From: Amanda Scholes on behalf of Planning.Responses
Sent: 15 March 2018 11:26
To: Planning Scanning
Subject: FW: AW/55/18/HH 3 The Orchard, Aldwick

2nd Conservation Officer comments

PROPOSED ELEVATIONS

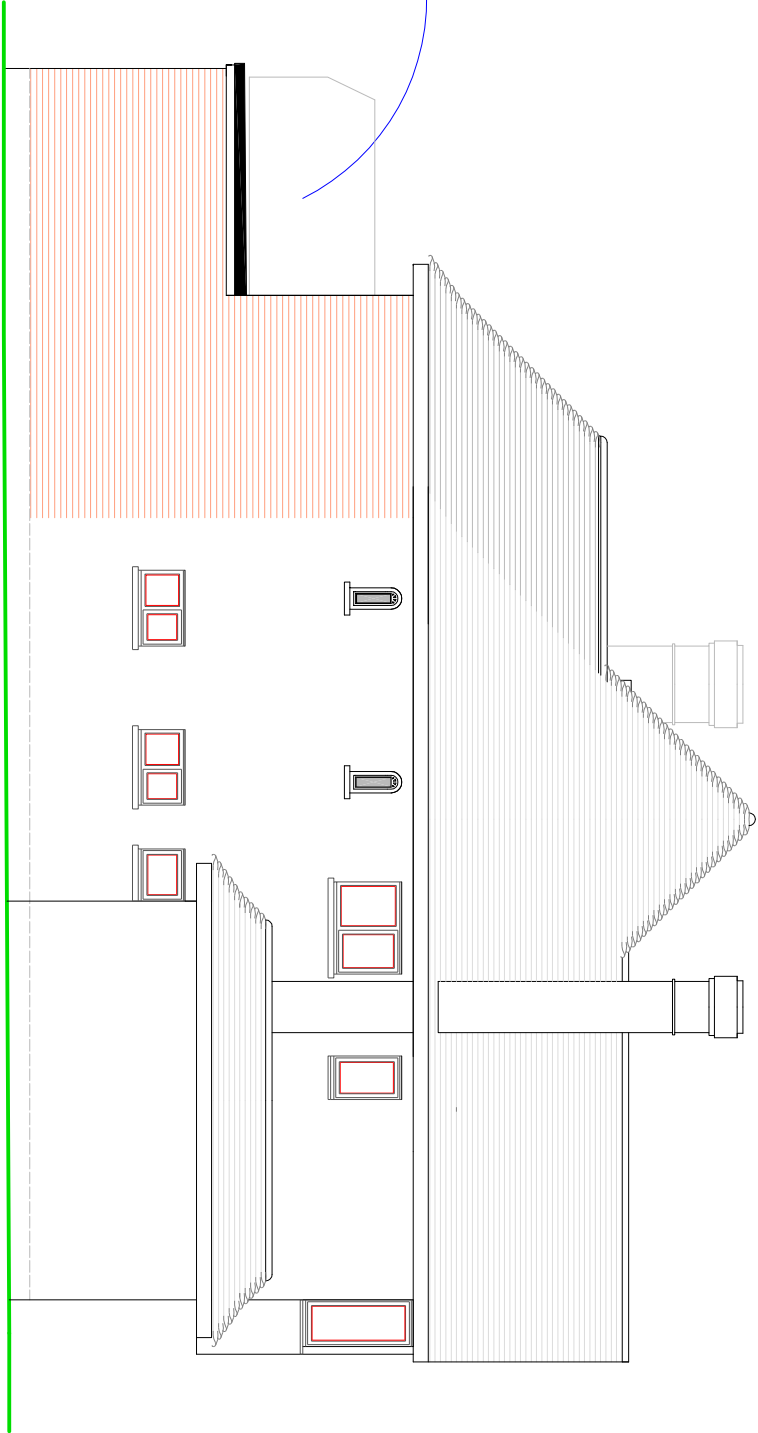
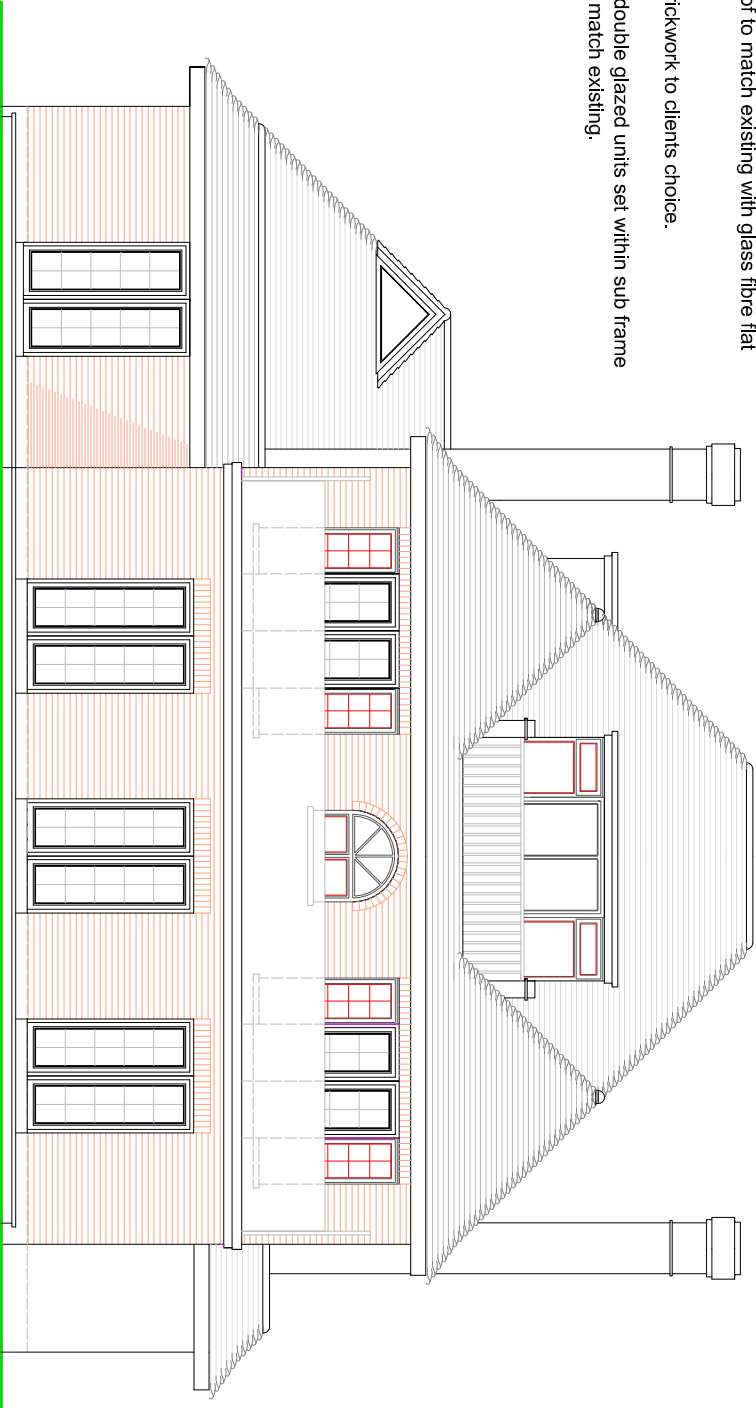
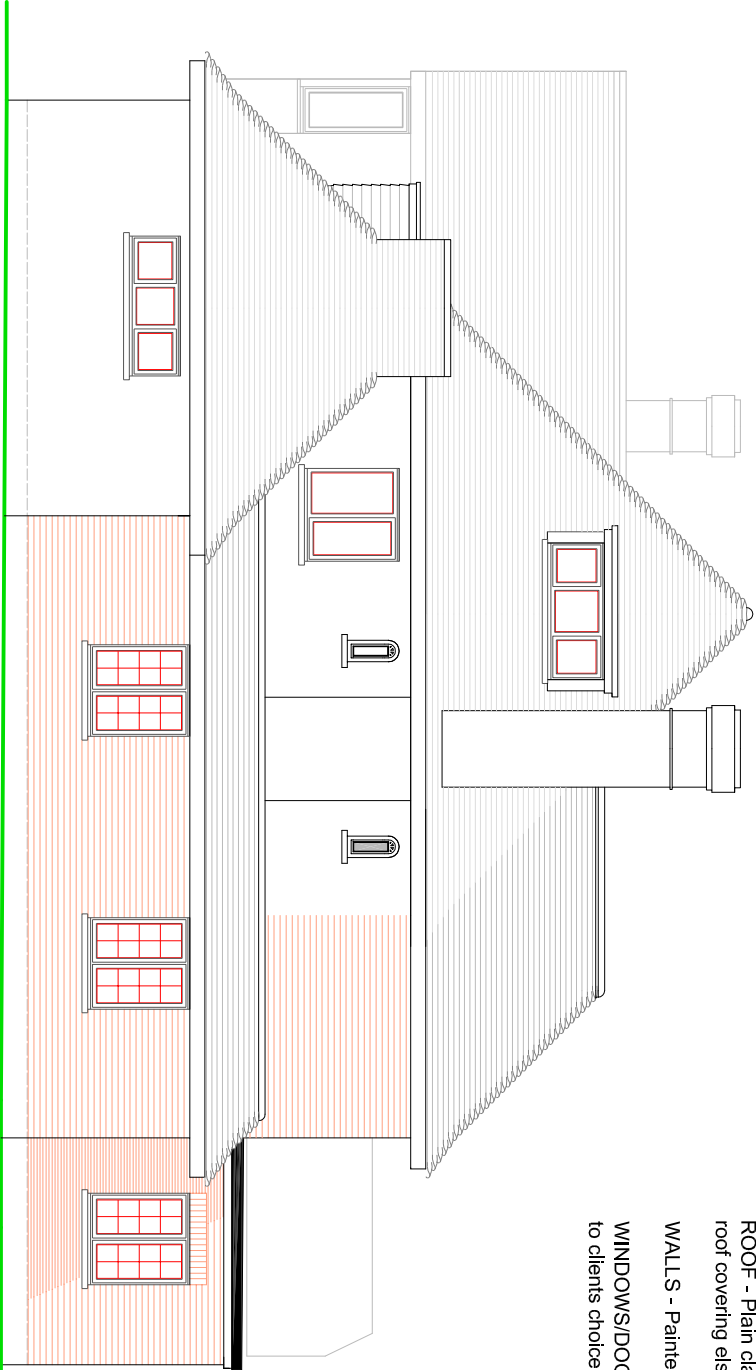
I'm not entirely sure what the confusion is on their part...? The balcony would be visible from the street, and glazing, although opaque, would be reflective... Is that their point?

Thanks for the email - I'm a little confused as they talk of non-reflective surface and also the need to retain visual permeability of the site.

Would you accept either a wrought iron effect balcony guarding on all three sides or if privacy to adjoining neighbours is sought, a brick side panel up to 1.7 metres high.

The client would prefer the former for aesthetics and also because the side boundaries are already pretty well screened from the existing first floor balcony areas – see attached photos.

Metal (PCA or wrought iron), would be considered acceptable alternative, and a preferred choice (as per my comments).
